P/51/11.

From: lilleyarchitecture [REDACTED]
Sent: 05 January 2012 11:26
To: Katherine Rawlins
Subject: RE: P/51/11 Extension, alteration and new detached garage 7 Webb Close Pagham
Attachments: 185 PL01rev01.pdf; 185 PL04rev01.pdf; 185 PL05rev01 A.pdf

To: lilleyarchitecture
Cc: Katherine Rawlins; Eve Hearsey
Subject: P/51/11 Extension, alteration and new detached garage 7 Webb Close Pagham

Proposed Site Plan
1:500@A3

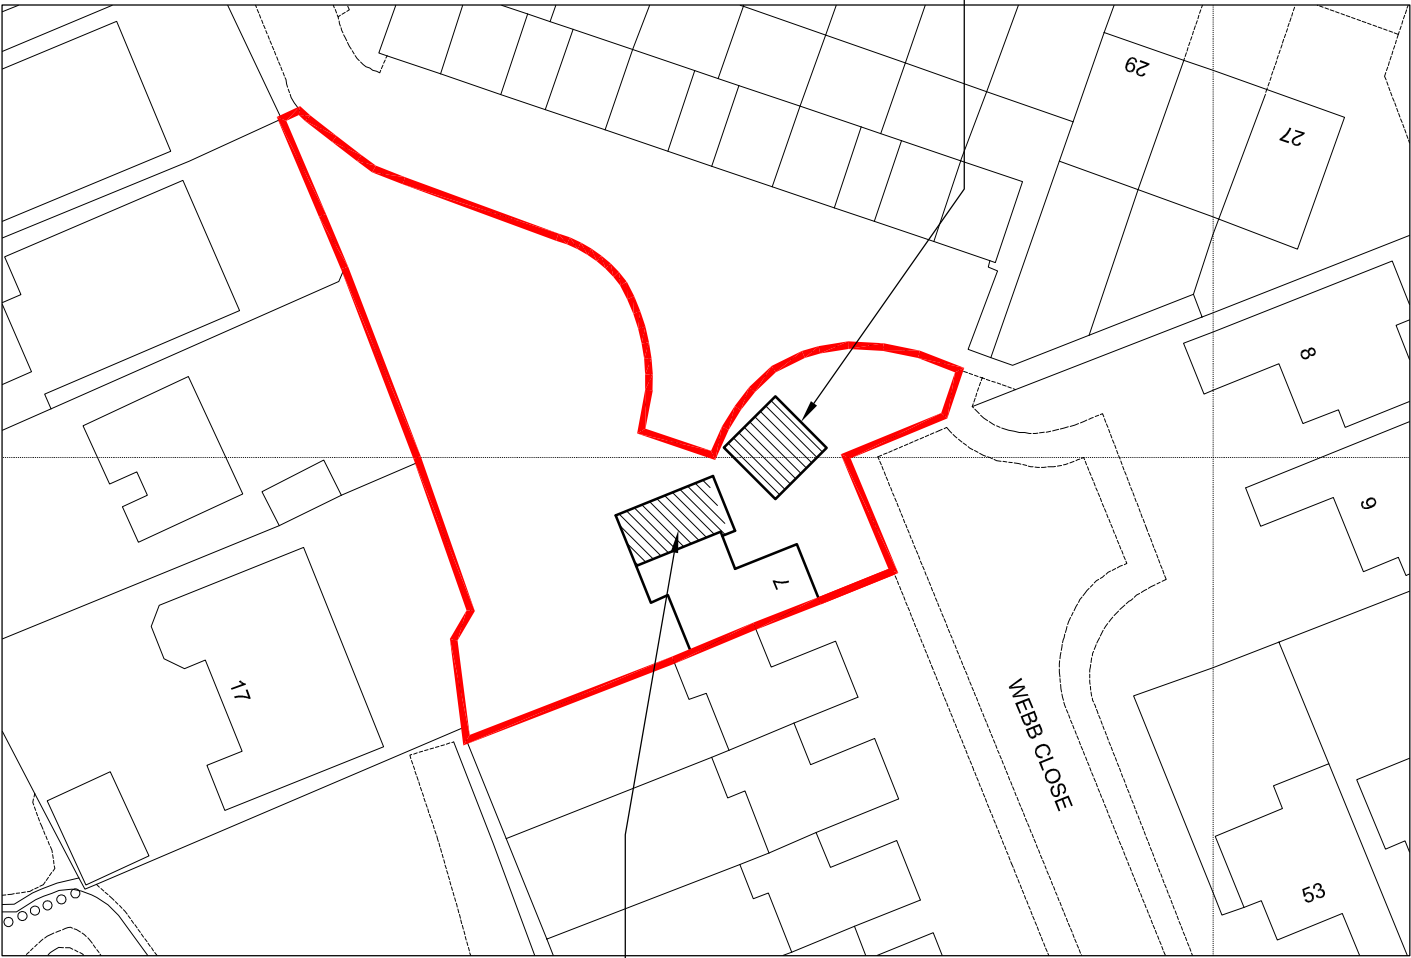
Thank you for your useful comments on revising the application. I take on board your suggestions that regarding the deletion of the garage proposal, addition of the mono pitch roof over the extension and rearrangement of the balcony. I note that you suggest that the balcony will only extend out 1 metre from the rear and a greater distance on the side to the west which overlook your clients garden and a car parking and garage area.

There is merit in what is proposed. However the proposal will be considerably be different to the submission which would require new advertising and notification of the Parish Council. In addition officers would still have to consider carefully the impact of any overlooking, even with the reduction in depth on the south elevation, on 17 given the change in levels and the orientation of mono pitch. Should the monopitch have it facing pitch roof sloping down to the western side or should it slope up from the front to the rear or should consist of two roof forms similar to the roof forms on eastern part of the existing building.

Finally the garage outbuilding has been removed from the proposals.
